**Maughanaclea Renewable Energy  
Development**  
Stage 1 Road Safety Audit

## Stage 1 Road Safety Audit

March 2026

Figure 15-29 Site access junction B on R585 - junction layout

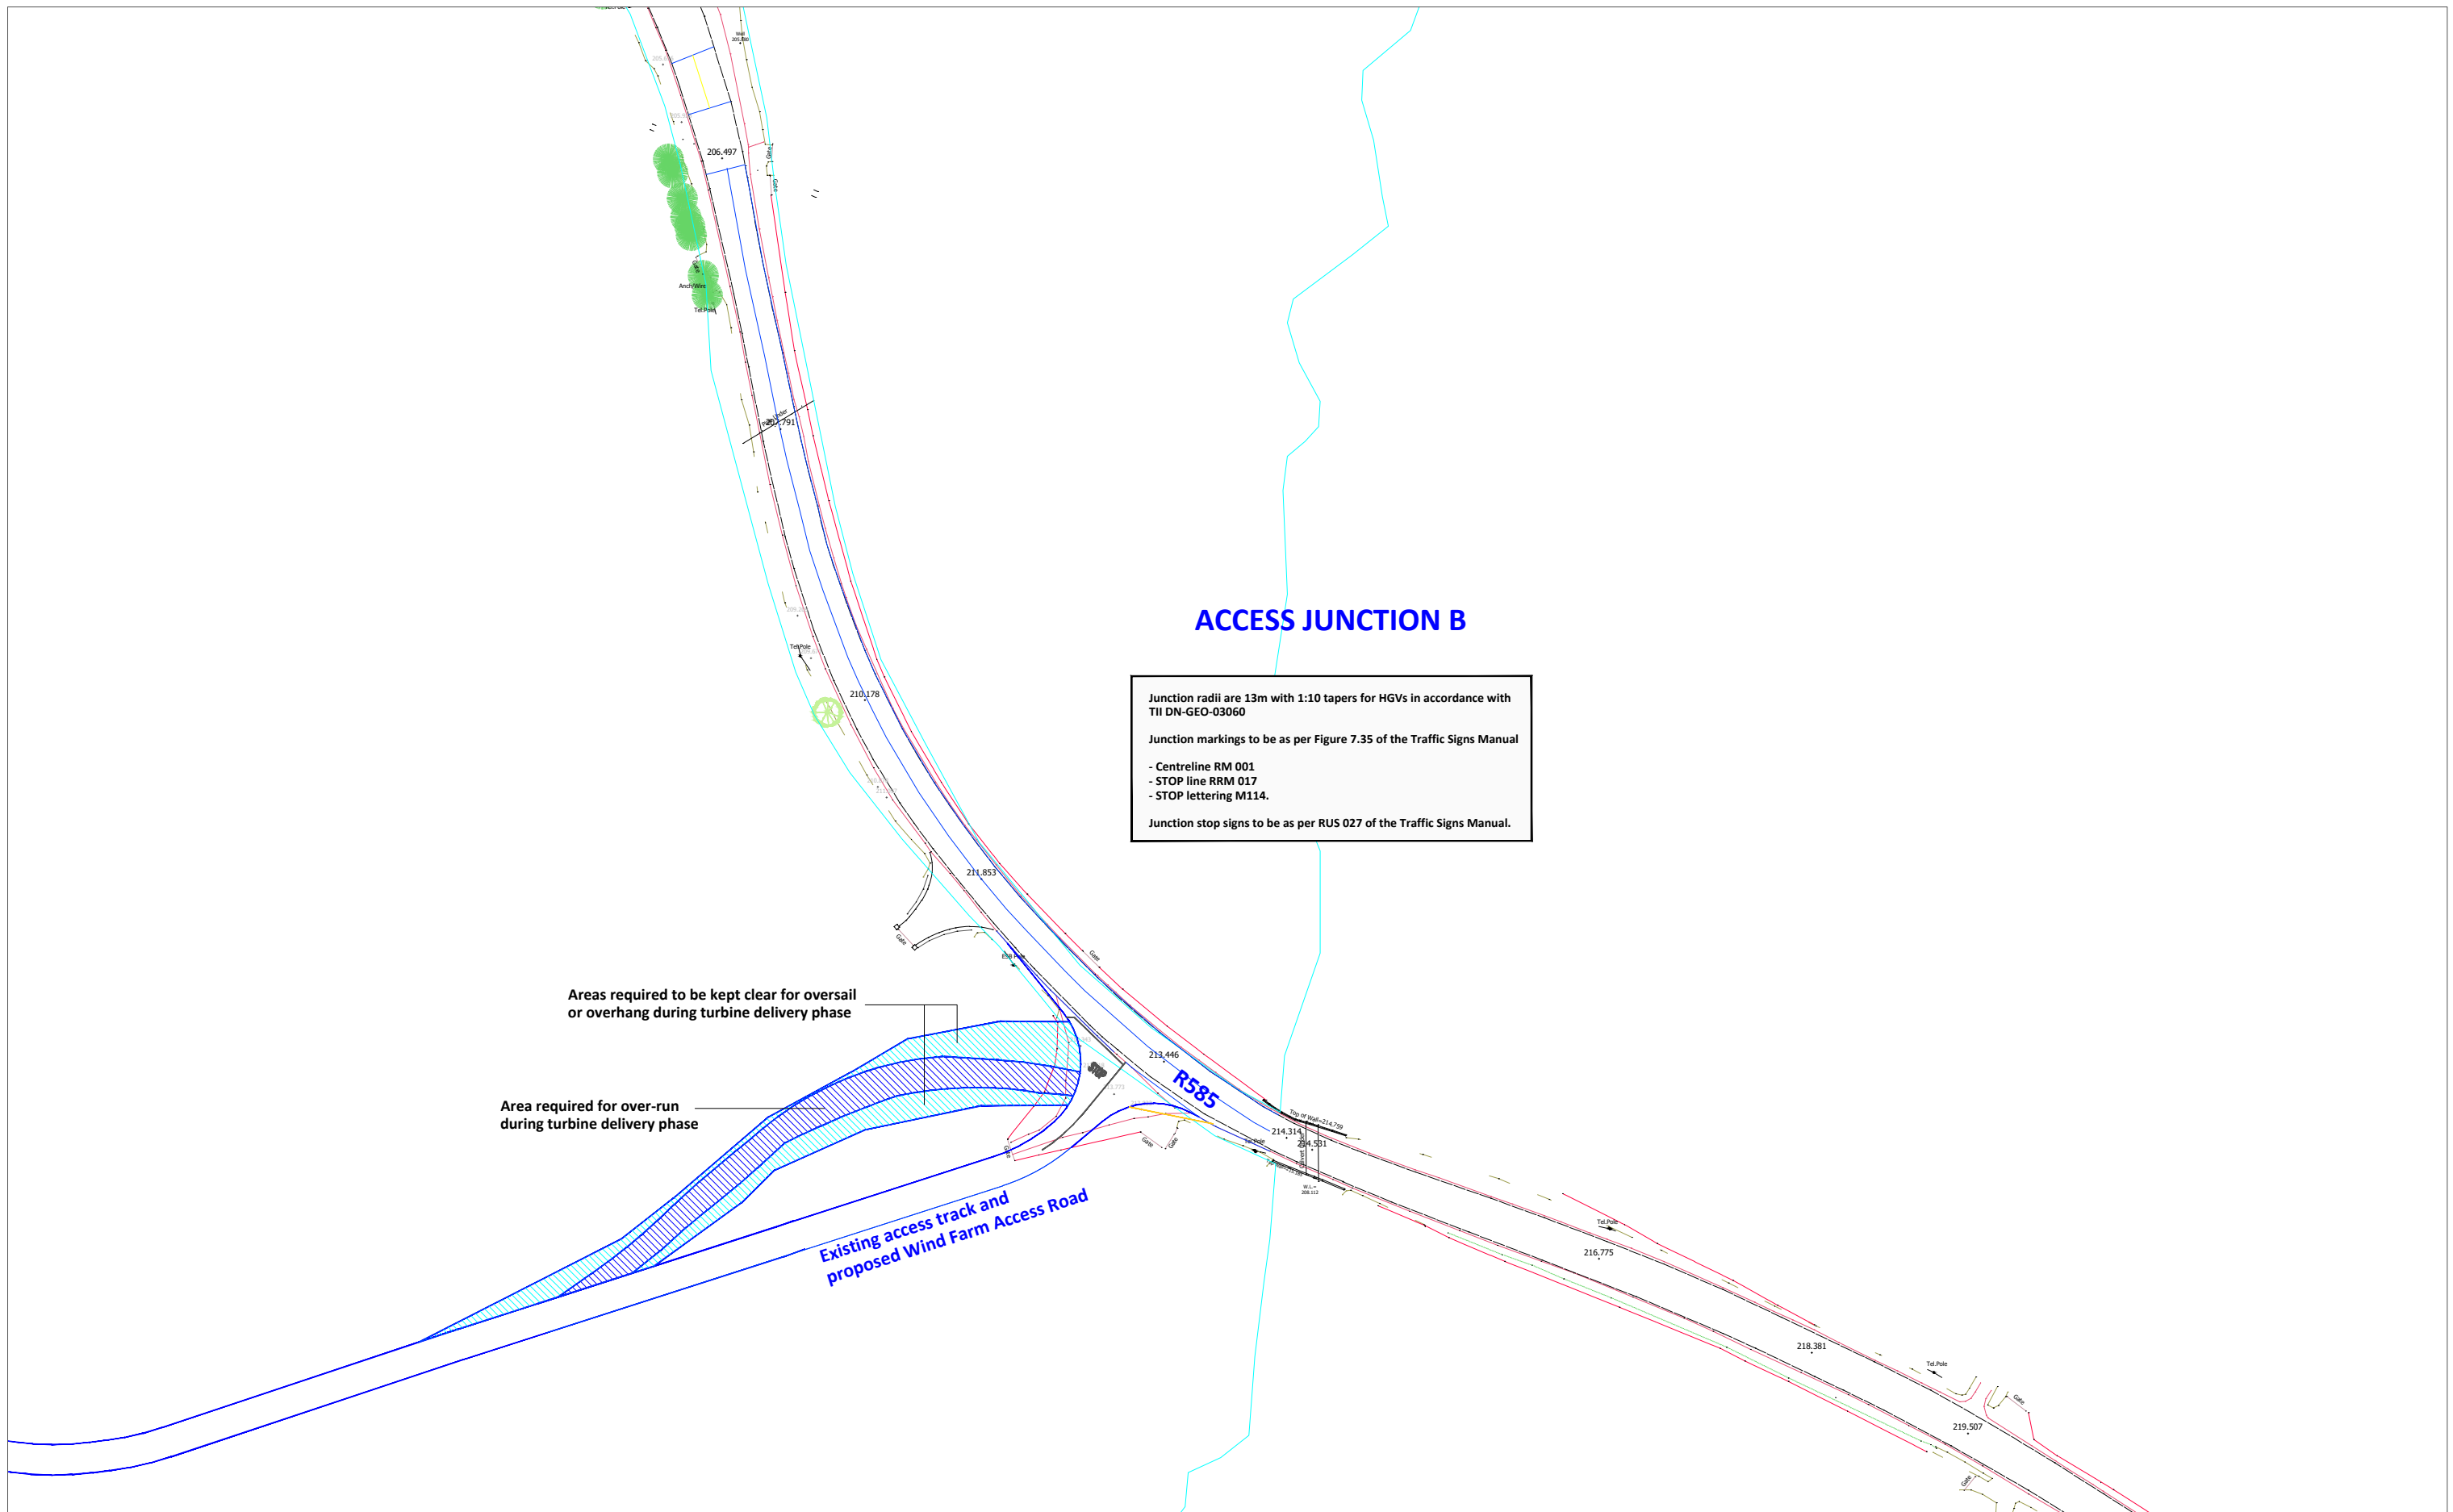
## 2.3 Problem: Passing Motorists Accessing Vehicle Overrun Area

**Location:** Junction B | Existing mainline carriageway to the south of the site

The over-run area might create confusion for passing motorists, who could access the overrun area by mistake, leading to sudden braking, loss of control or conflicts with construction traffic.

The Designer should ensure that a suitable barrier is put in place to prevent passing motorists from accessing the abnormal load overrun area when it is not in use.

## 2.5 Problem: Steep Downhill Gradient Causing Ponding

**Location:** Junction B | R585 Regional road to the west of the site entrance

The site access road's steep downhill gradient is likely to channel surface water runoff onto the road from the site entrance where it could accumulate and wash out unbound surface materials onto the carriageway leading to loss of control type collisions.

Suitable drainage measures should be provided here to prevent ponding and unbound surface materials from being washed into the carriageway.

2.4	Yes	Yes	It is confirmed that the visibility splays and forward visibility shown in Figure 15-30 will be provide at all times.	Yes
2.5	Yes	Yes	Suitable drainage will be installed as part of the proposed improved junction.	Yes

Figure 15-30 Site access junction B on R585 - visibility splays

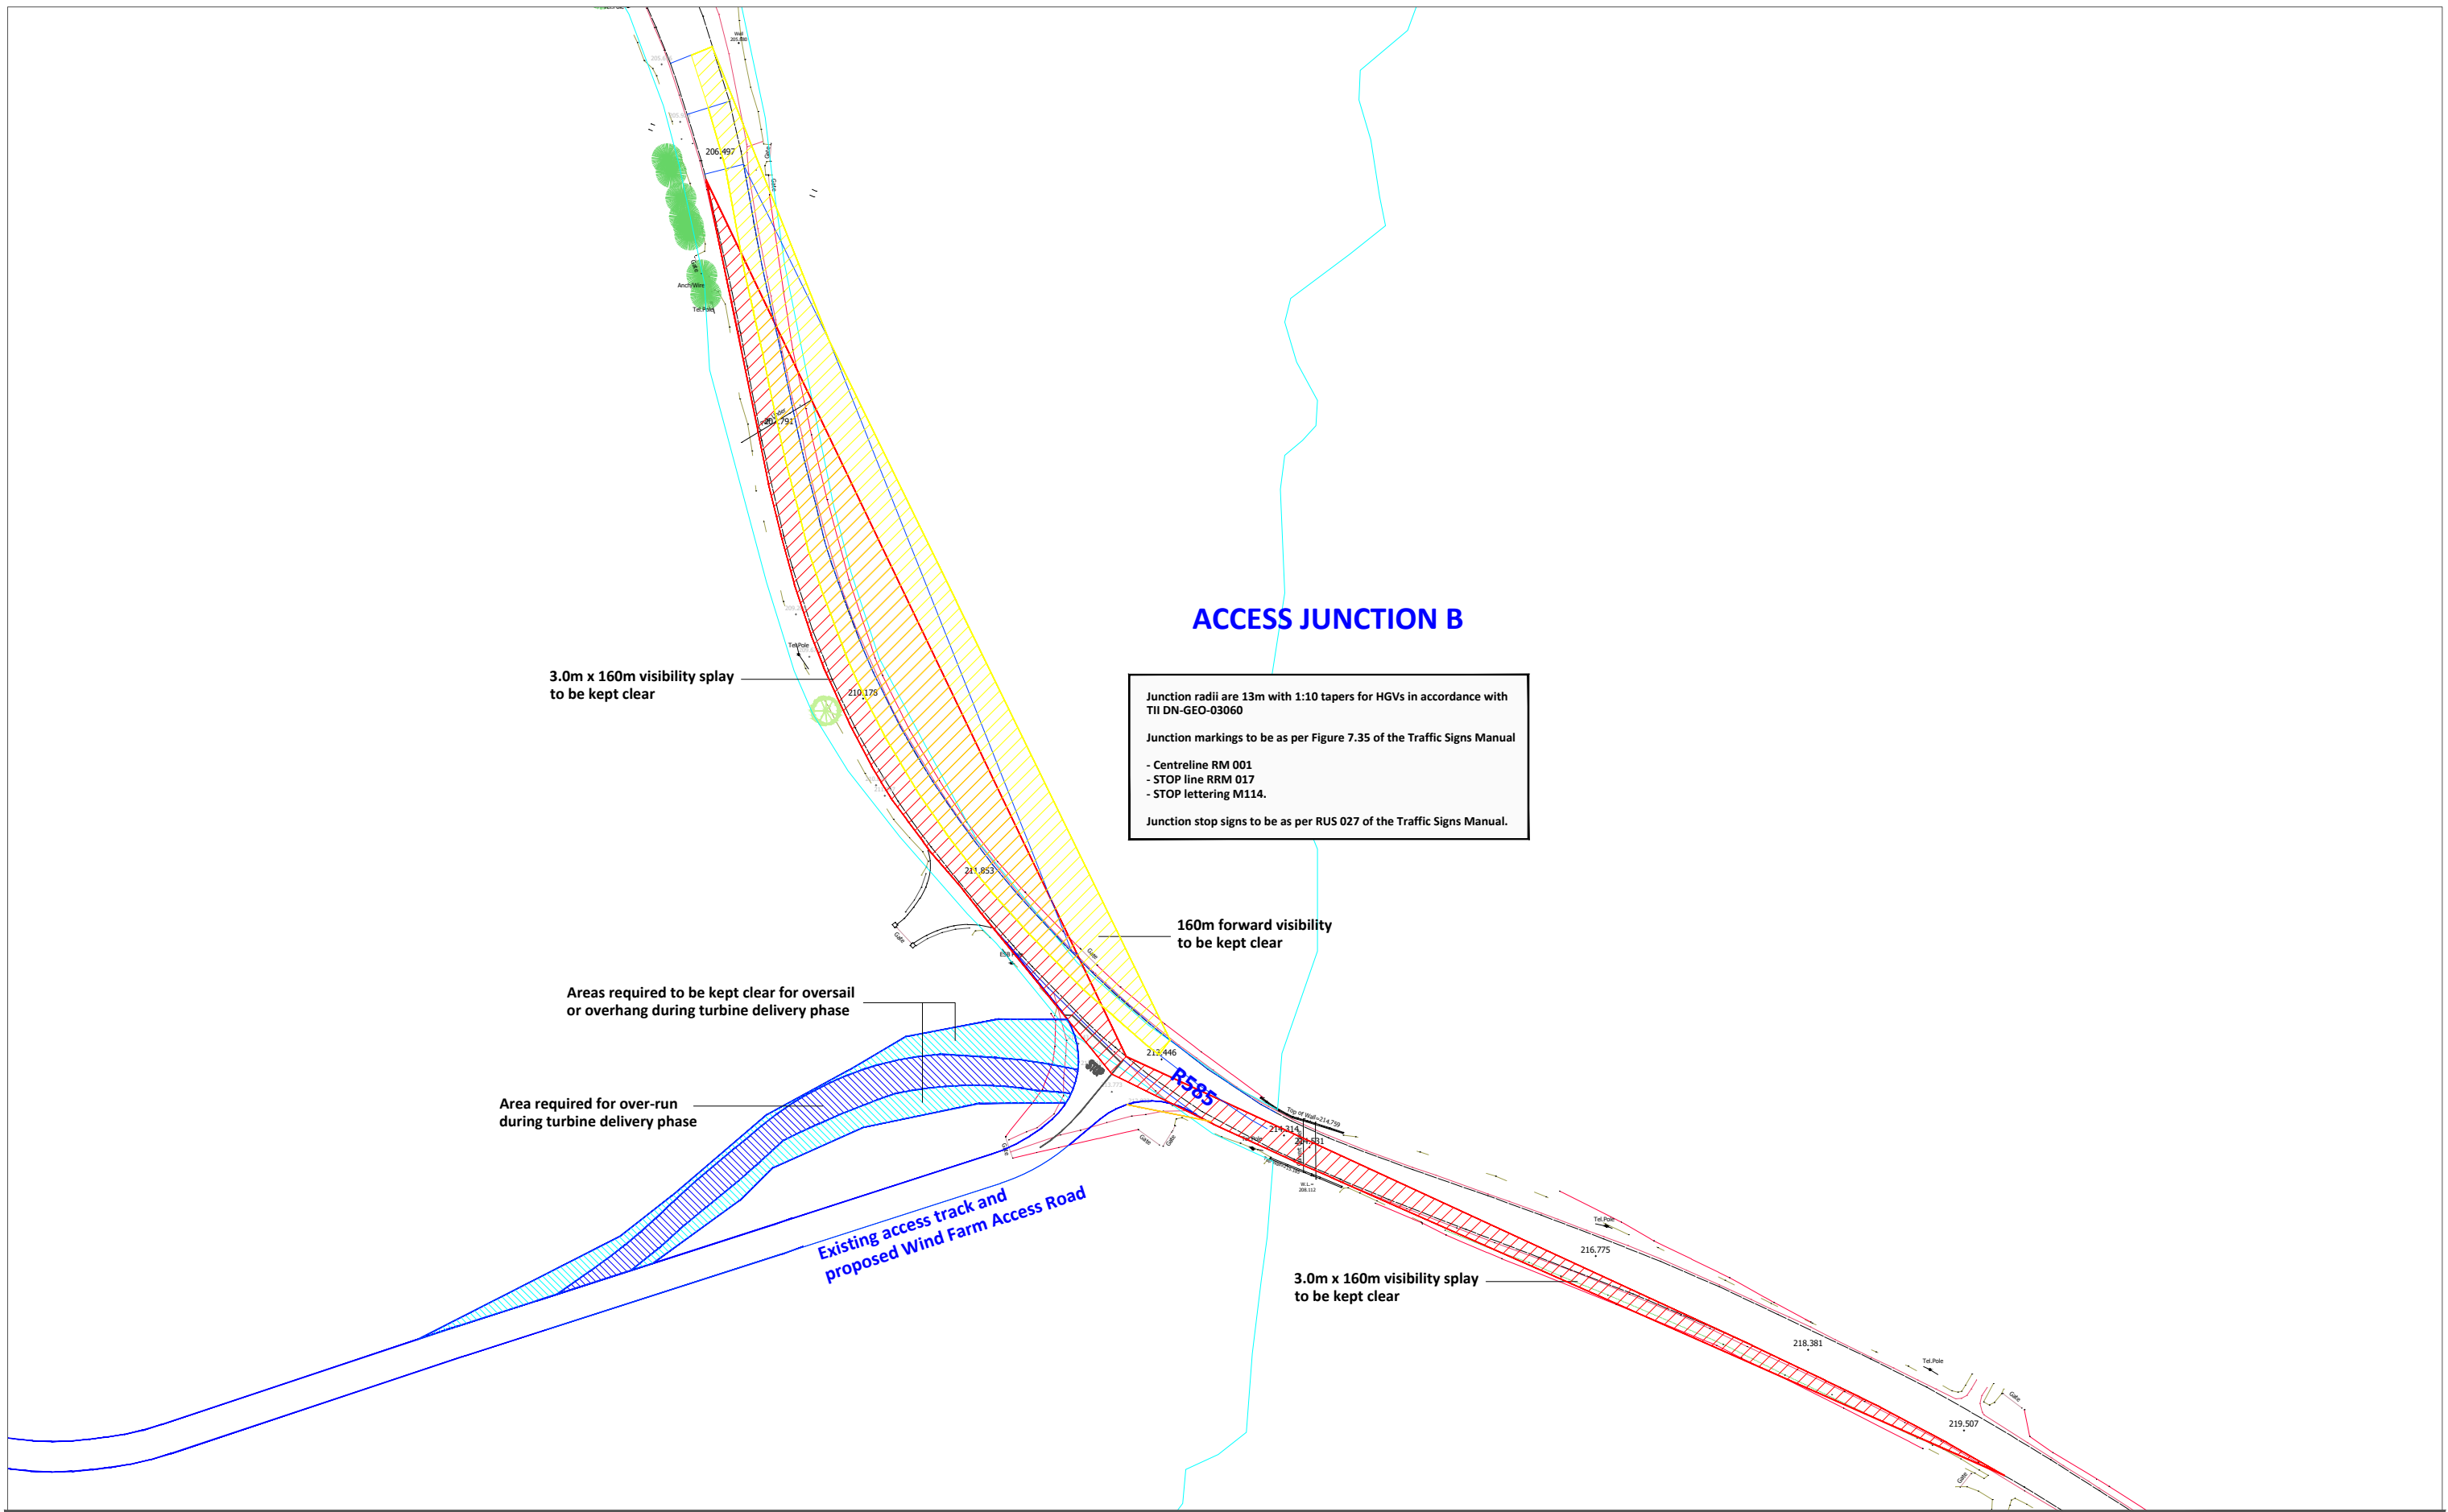
## 2.4 Problem: Visibility Splays Partially Obscured

**Location:** Junction B | Existing boundary treatments either side of access

Drivers attempting to leave the access will have their view blocked in both directions by the existing field boundary. This limited visibility could increase the risk of side-impact collisions at the access.

The field boundary should be modified to ensure that an appropriate level of visibility can be provided for drivers exiting the access
